# BUILDING PERMIT

Job ID: 2011-07-1810-SF

has permission to build a new Single Family Residence (See UI Permit # 10-1163)

Proposed Use: Single Family / New 24' x 32' cape style home with 10' x 10' deck.	Proposed Project Description: New 24' x 32' cape style home with 10' x 10' deck.
---	---

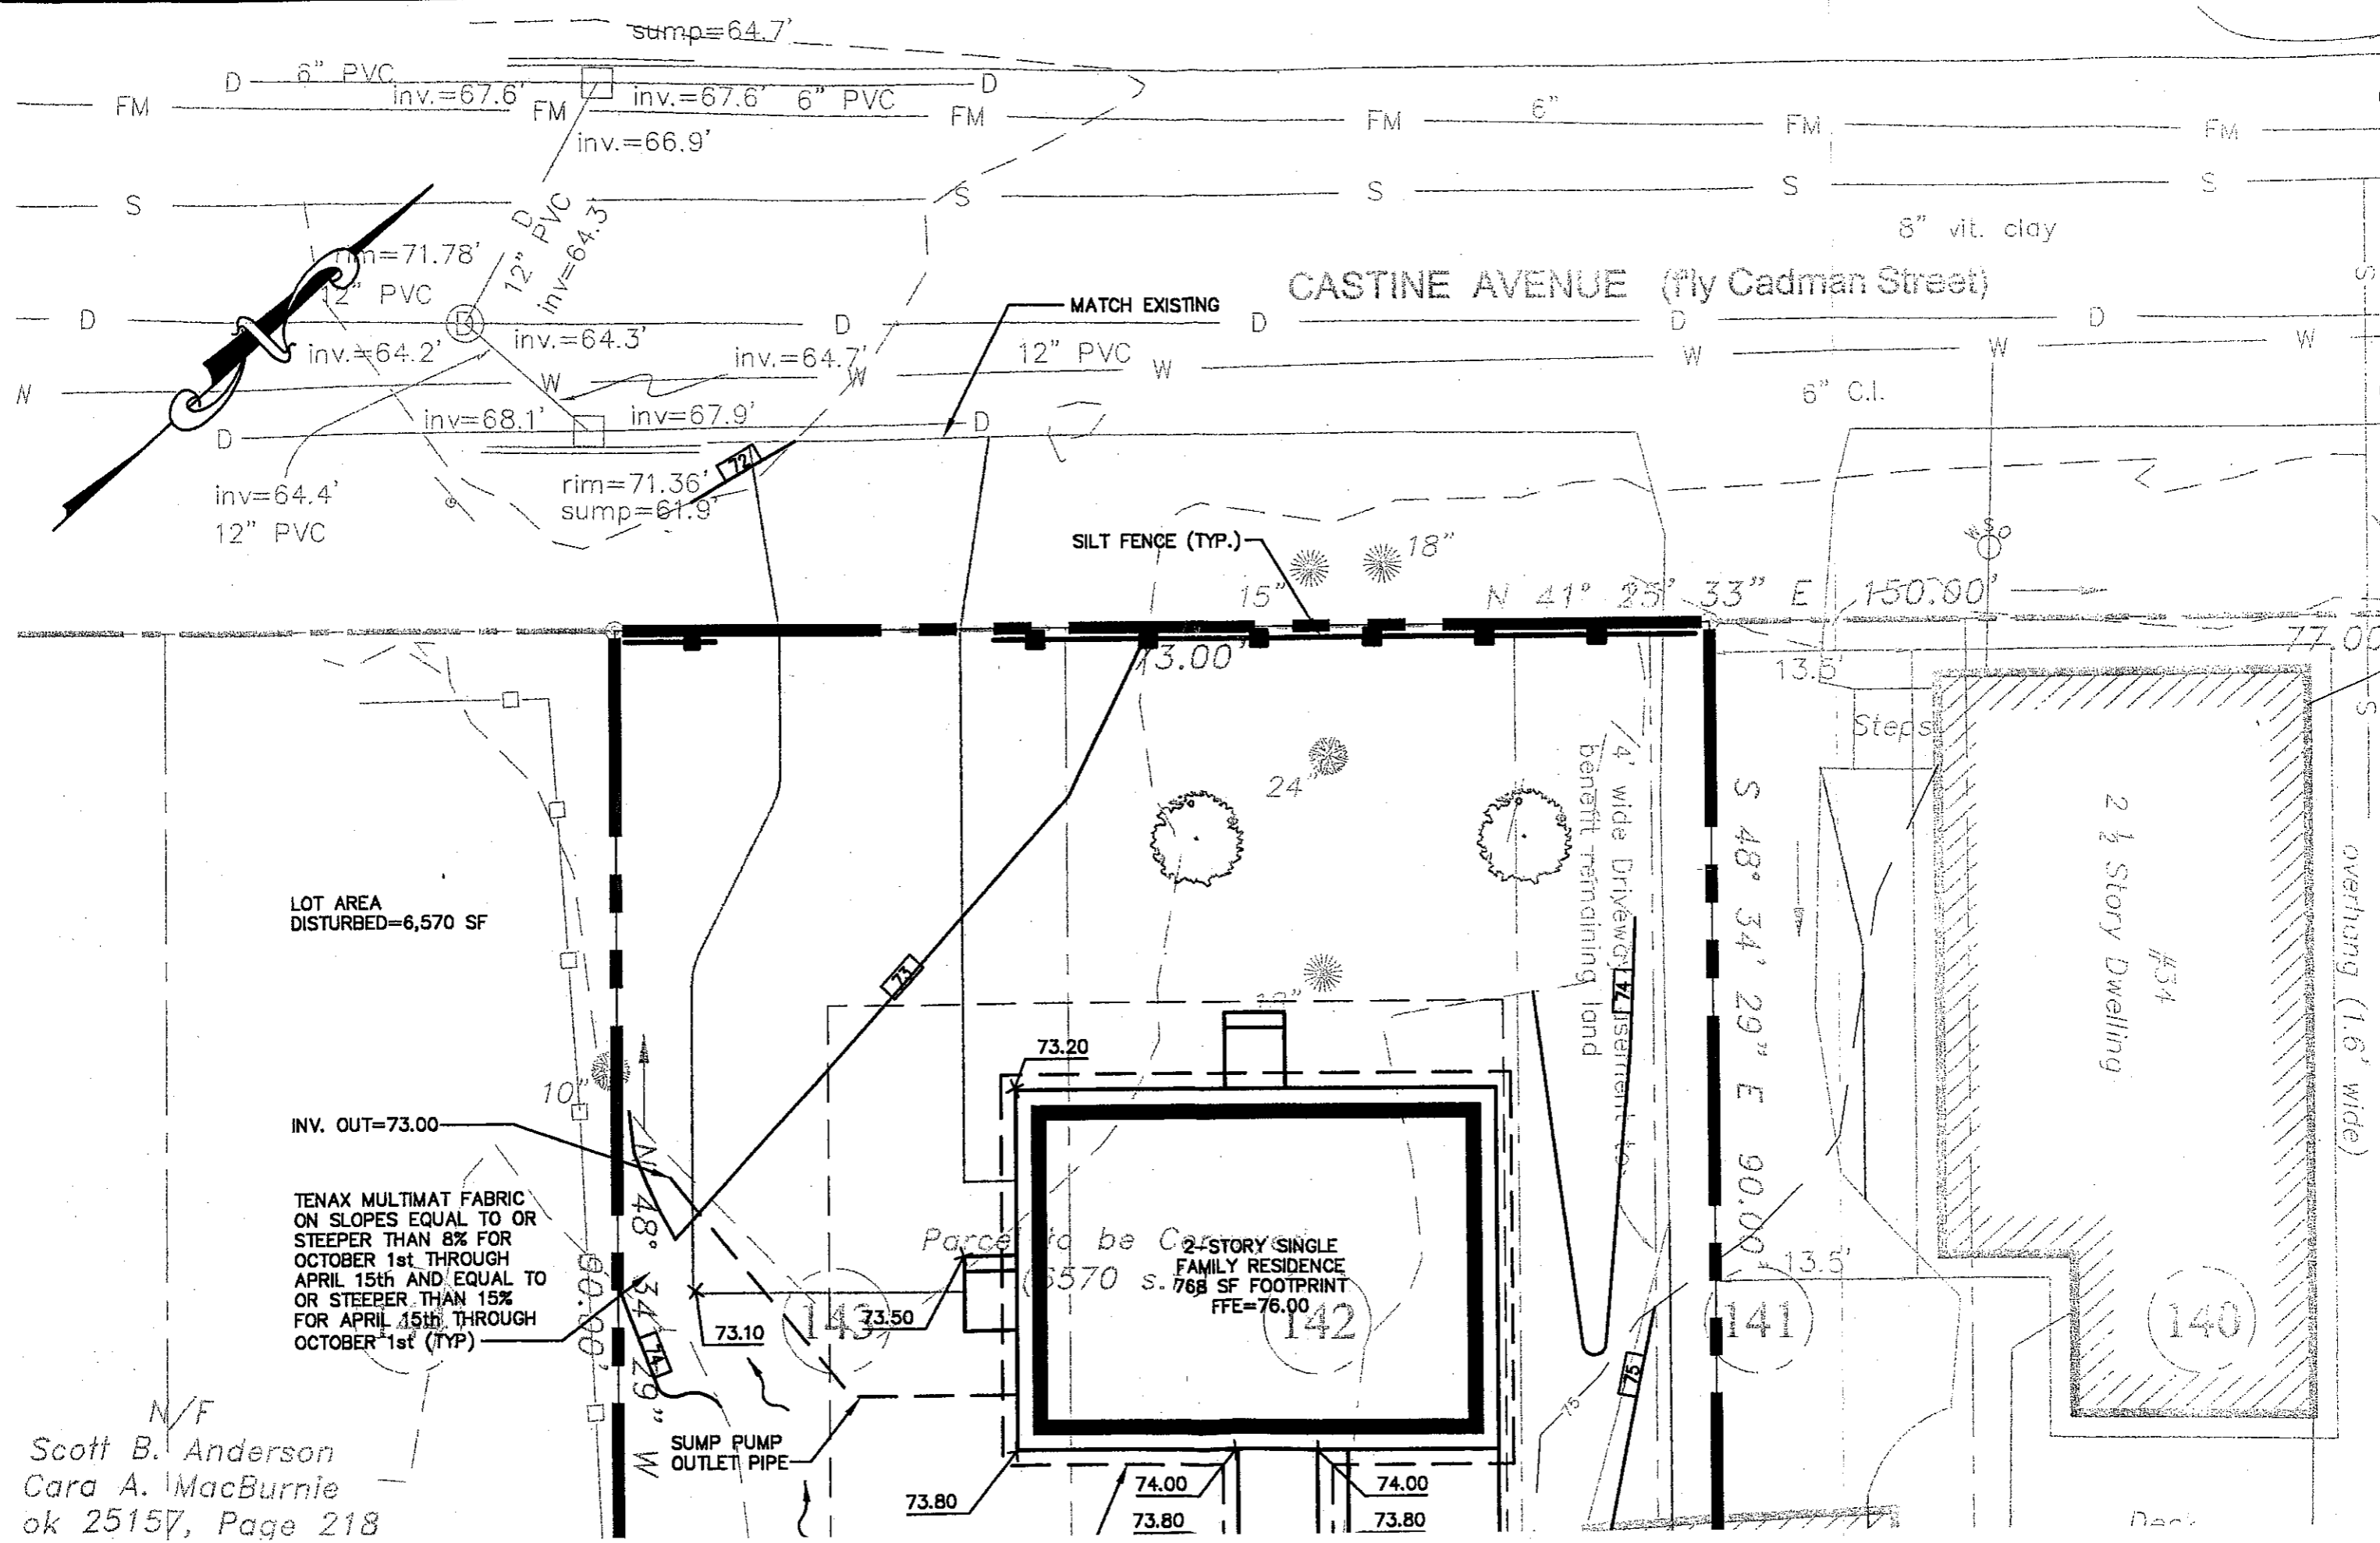
9/27/2010-amachado: Left vcm for Jim Wolf to call me. Need a copy of Cynthia Mcallister's deed. Regarding the driveway easement for the existing house, need a written description of it & driveway needs to be shown on plan (right now it encroaches on proposed deck). Garage needs to be removed before the building permit is issued. Need deed description for new lot including driveway easement that will be recorded. Location of bulkhead does not match on the site plan and building plans.

10/18/2010-amachado: Received revised site plan & building plans.
